# WISWELL PARISH COUNCIL

**Planning Application No: 3/2011/0858**  
**Proposed erection of a summerhouse to replace the removed garden shed**  
**36 Pendleton Road, Wiswell, Clitheroe, BB7 9DD**

Description
Proposed Summer House
Plans and Elevations

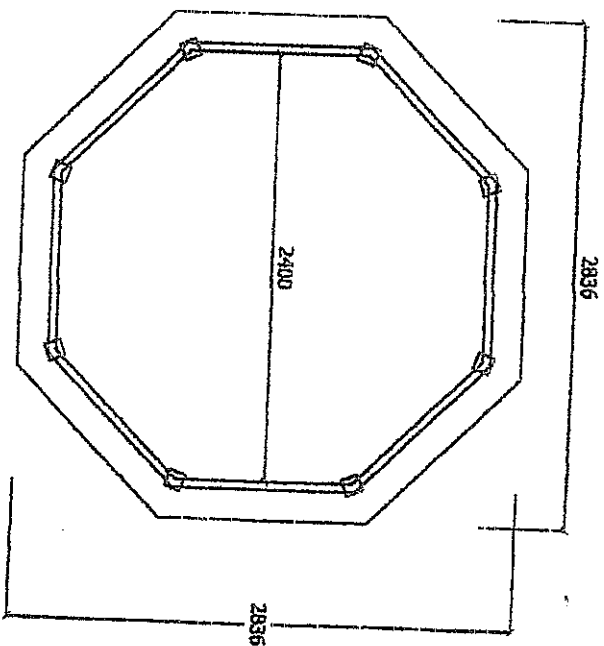
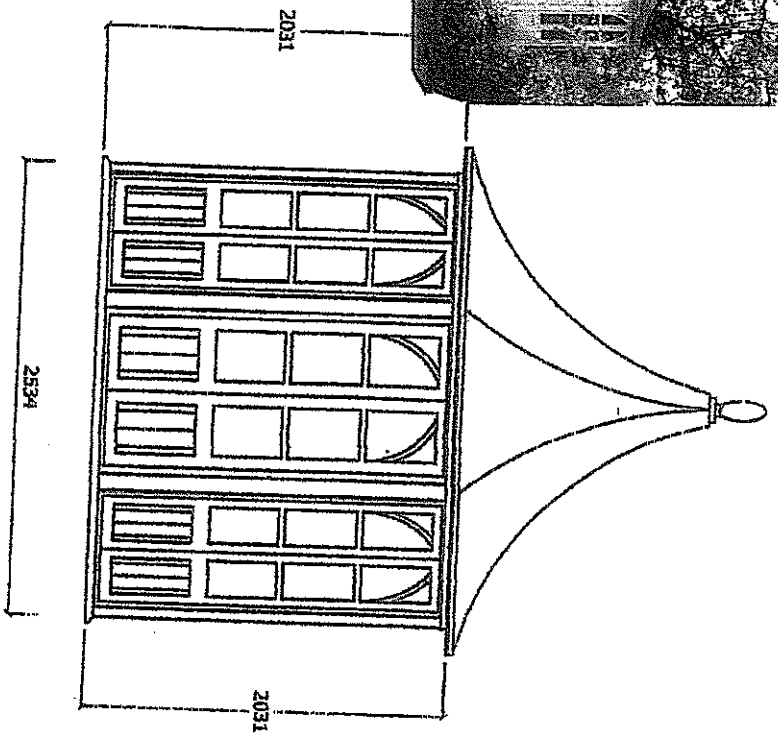
The above application has now been considered by members of the Parish Council. The Councillors have no objections to a summer house in general but the roof design and height of the proposed building are of concern in a conservation area as the roof would be clearly seen above the existing hedge.
